## Moorebank Precinct West (MPW) Stage 2 (SSD 7709) Response to Submissions – issues raised by Transport for NSW

## ATTACHMENT A - RESPONSE TO ISSUES RAISED BY TRANSPORT FOR NSW

CONCURRENT A-DOUBLE & B99 VEHICLE MANOEUVRE
1:250 SCALE

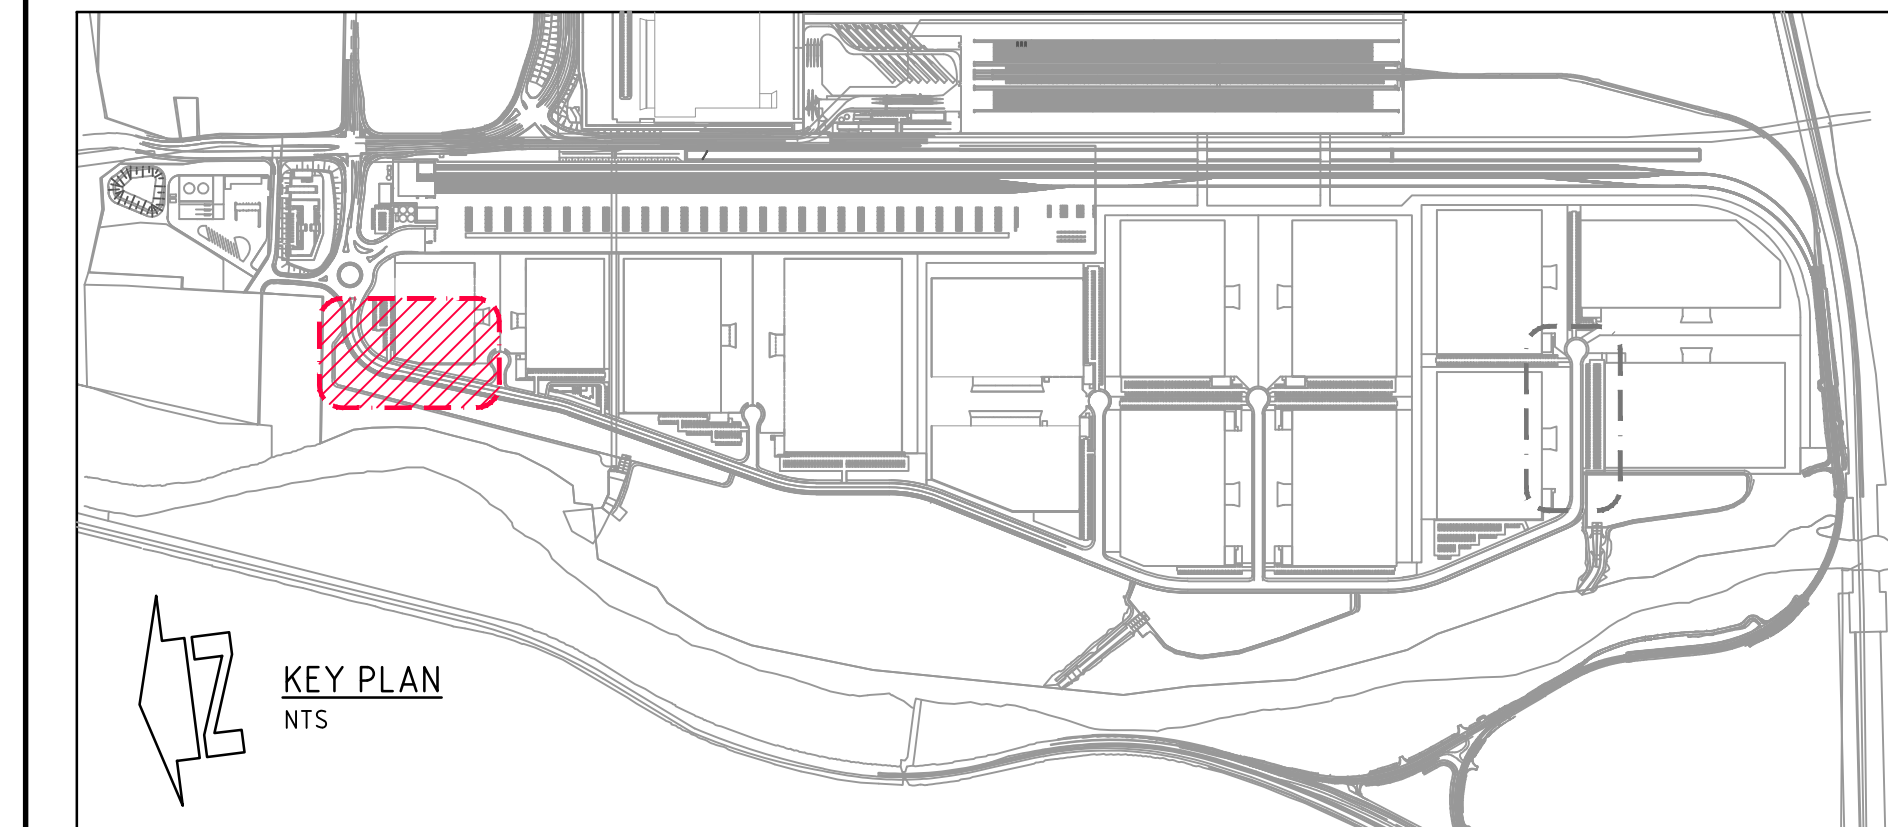
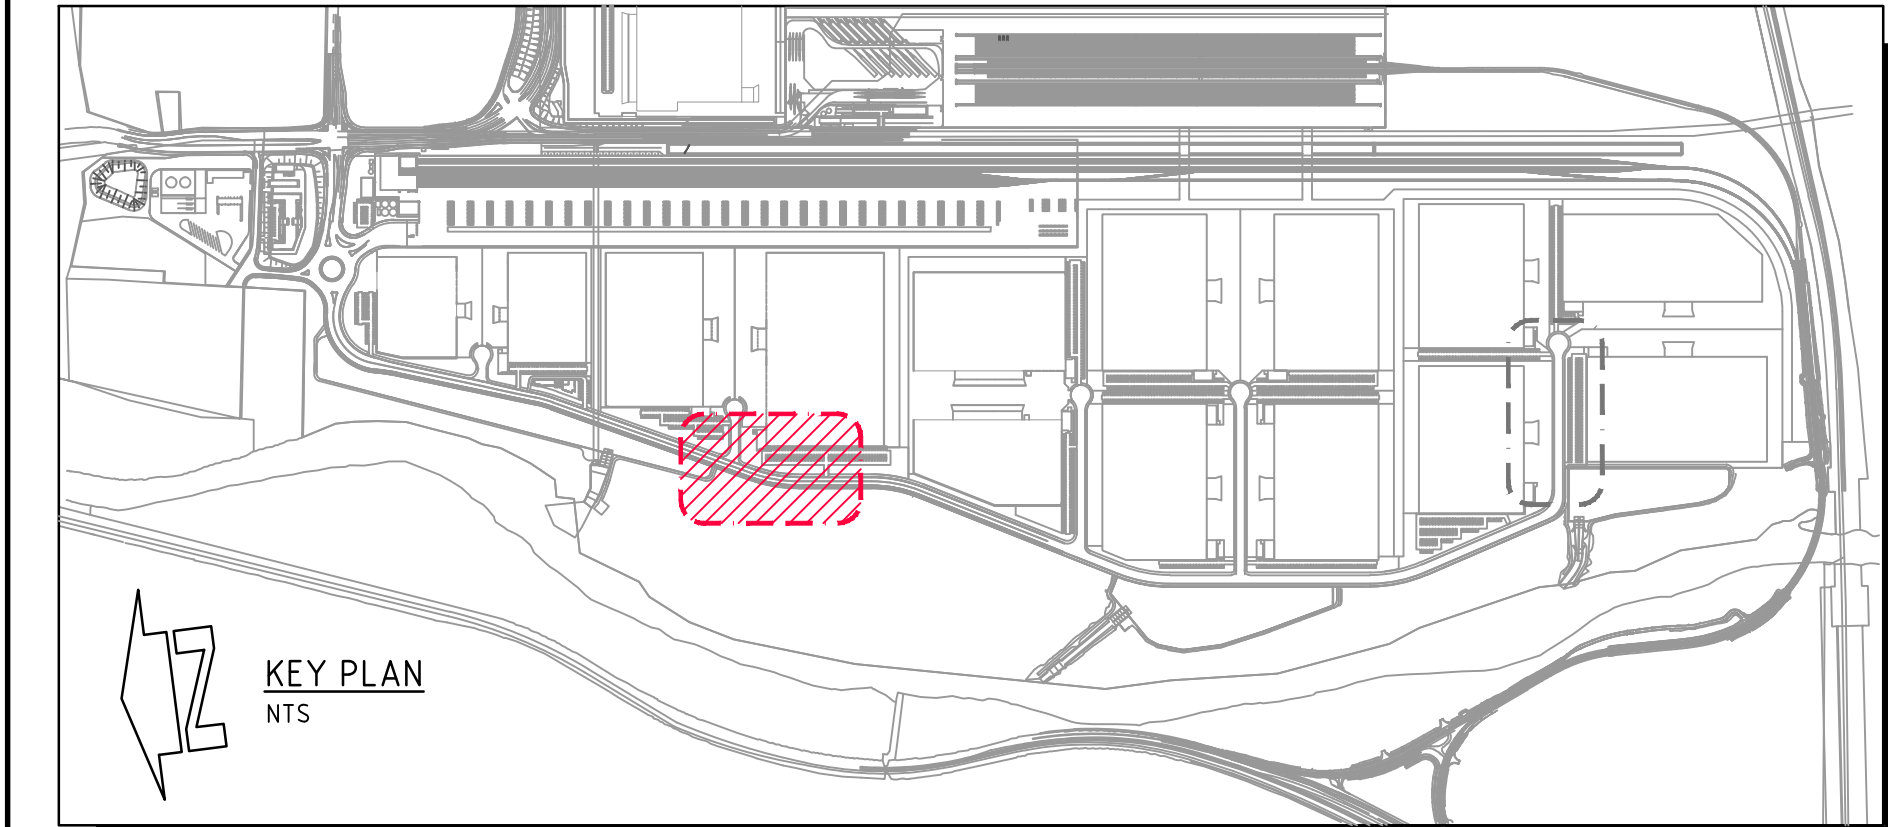
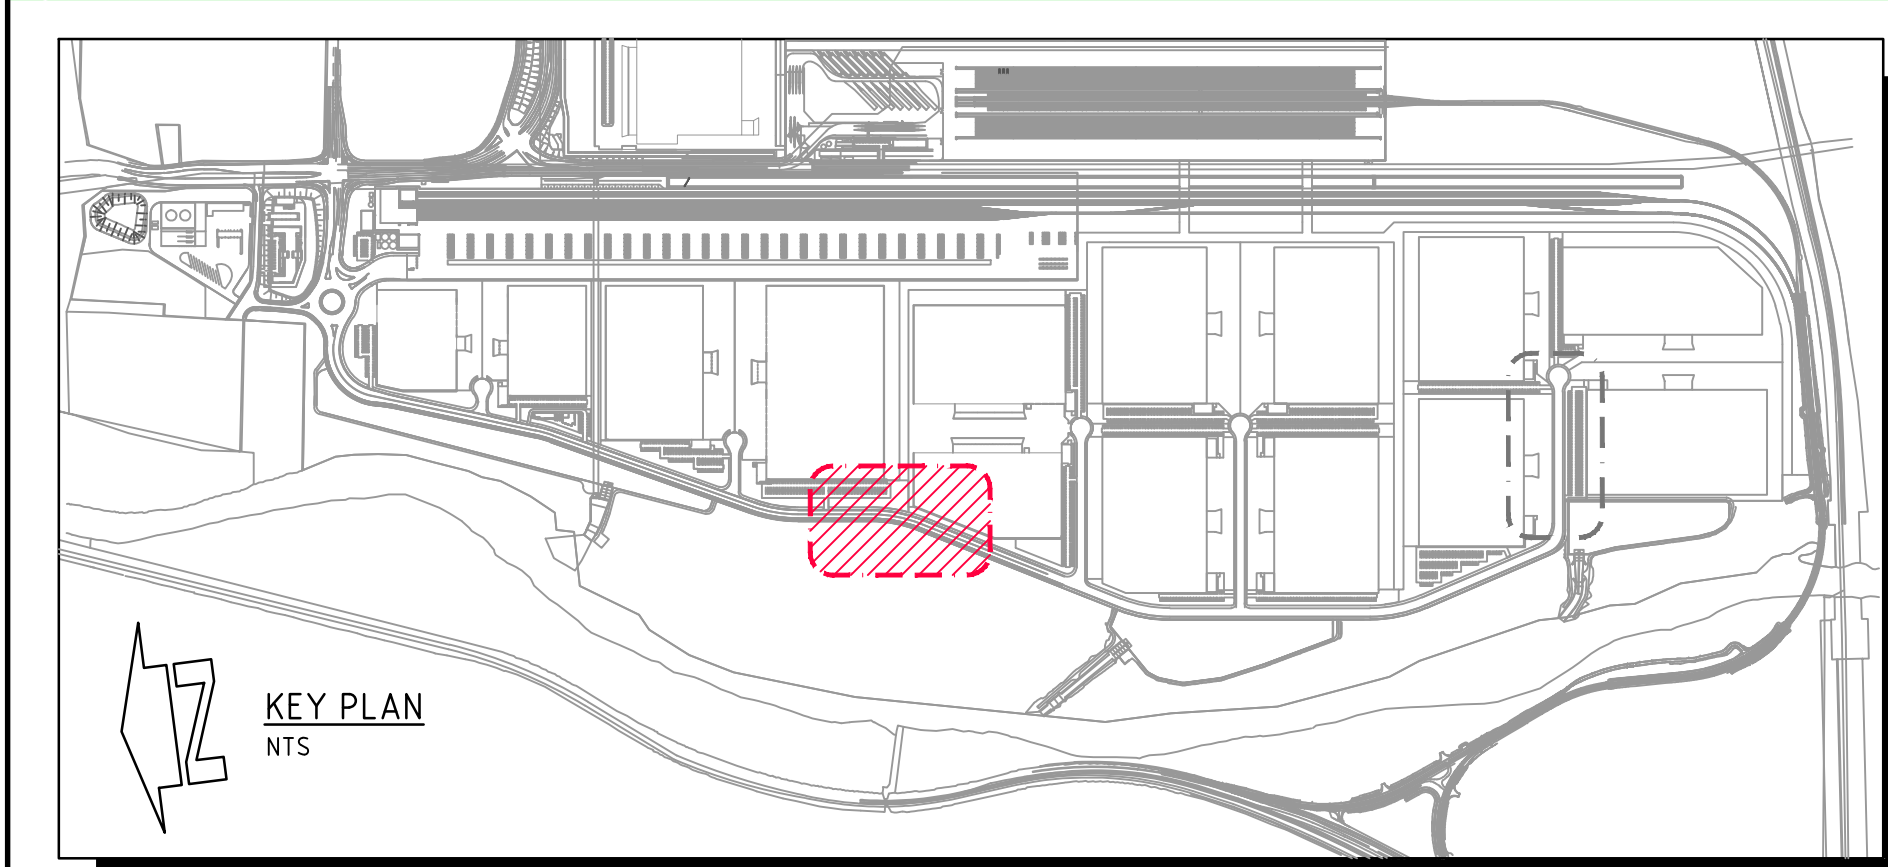
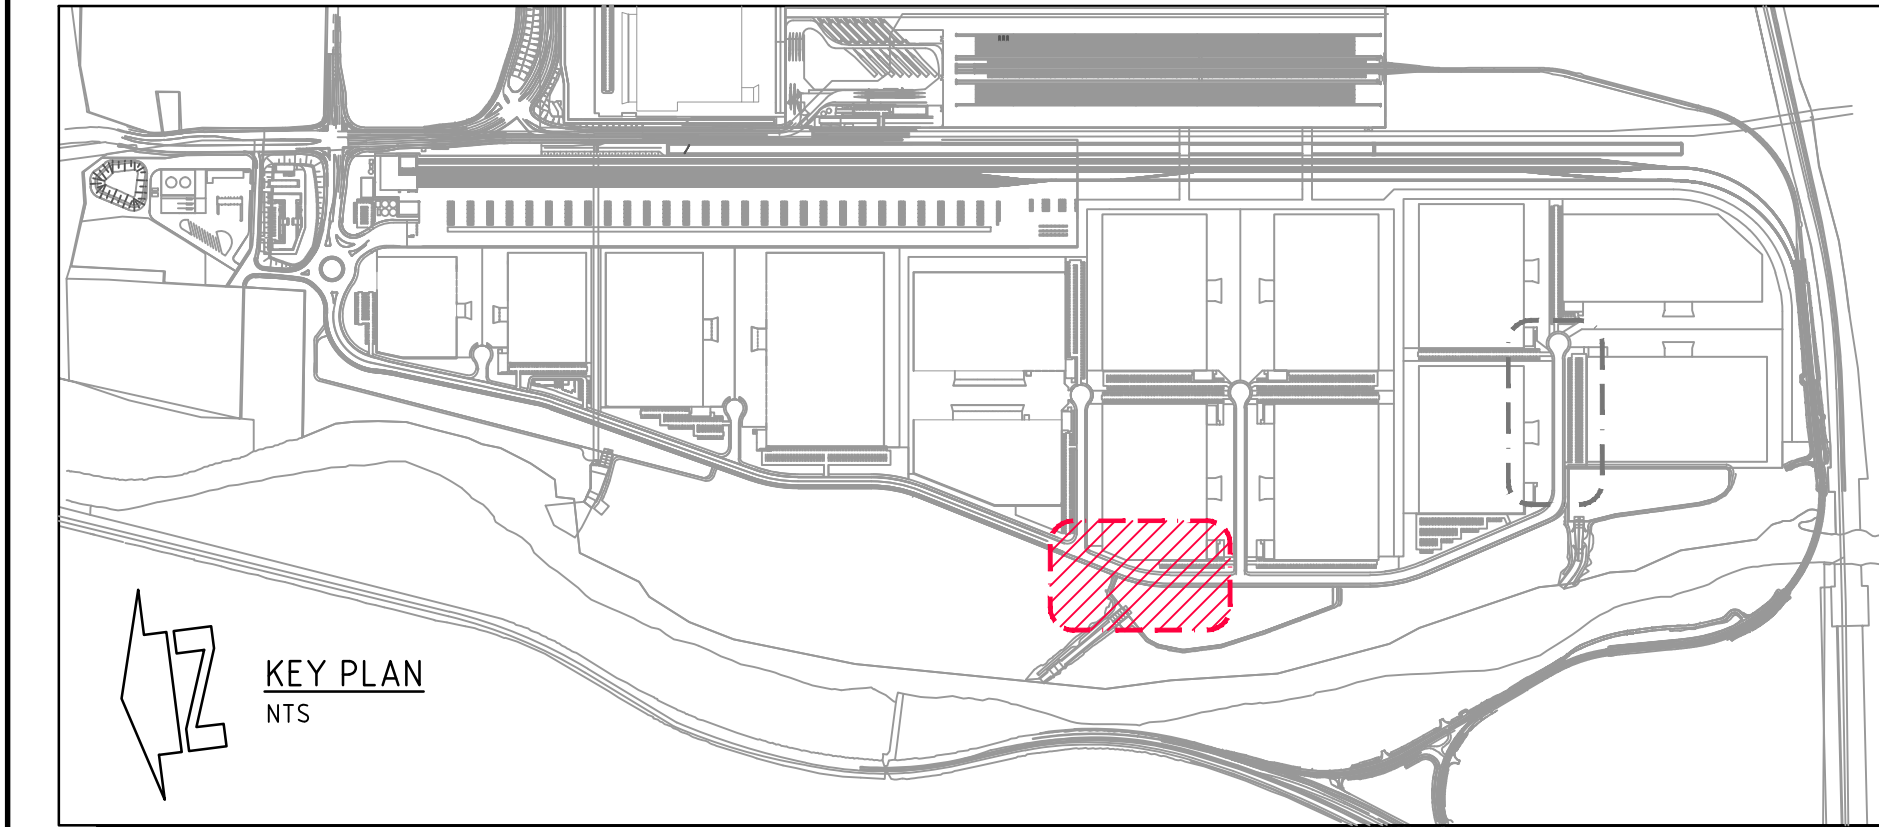
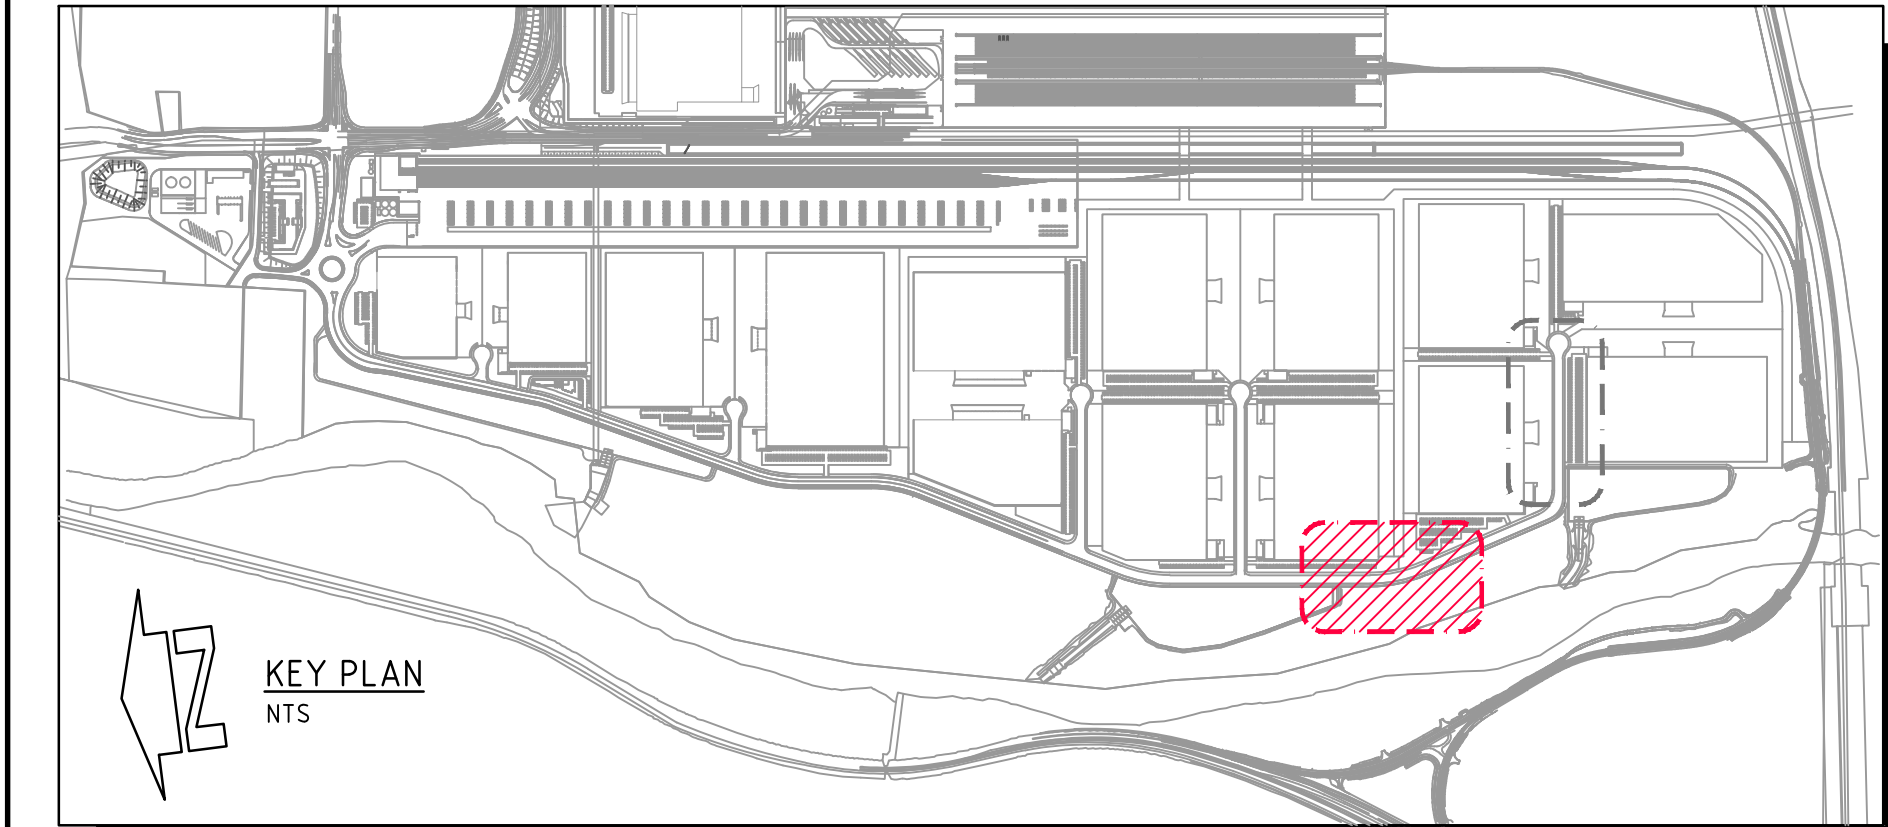
Aspect	Comment	Response	Reference
Adequacy of	Adequacy of Environmental Assessment against the SEARs  TfNSW is of the opinion that SEARs component 4i has not been adequately addressed (provide details of service vehicle movements and site access arrangements (including vehicle type and likely arrival and departure times of service vehicles)).  In their submission, TfNSW noted that 'Not considered as addressed in the sections nominated by the proponent i.e. Section 1.5, Section 1.6, Section 1.7 and Section 5.1'.	Service vehicle movements and site access arrangements	Section 1.5, 1.6,
Assessment against the		Service vehicles would access and egress the Proposal site via the Anzac Road / Moorebank Avenue intersection and travel within the Proposal site via the internal road network (refer to the revised architectural drawings at Appendix B for more information regarding the intersection layout and internal road network layout).	1.7 and 5.1 of the OTTIA (Appendix M of the EIS)

Both the Anzac Road / Moorebank Avenue intersection and internal road network has been designed to accommodate A-doubles. As service vehicles would be smaller than an A-double, adequate turning provisions will exist for service vehicles throughout the Proposal site. Site access arrangements that would apply to service vehicles are described in Section 5.4 of the OTTIA.	
		Service vehicle type and likely arrival and departure times	
		At the time of writing the EIS and this report, the type of service vehicles, and their likely arrival and departure times were unknown, as service contractors have not yet been engaged for the operation of the Proposal. As a result, the service vehicle types to be used are currently unknown. The likely arrival and departure times of service vehicles at the time of writing is therefore unknown, and would be dependent on the service contractors, once identified.
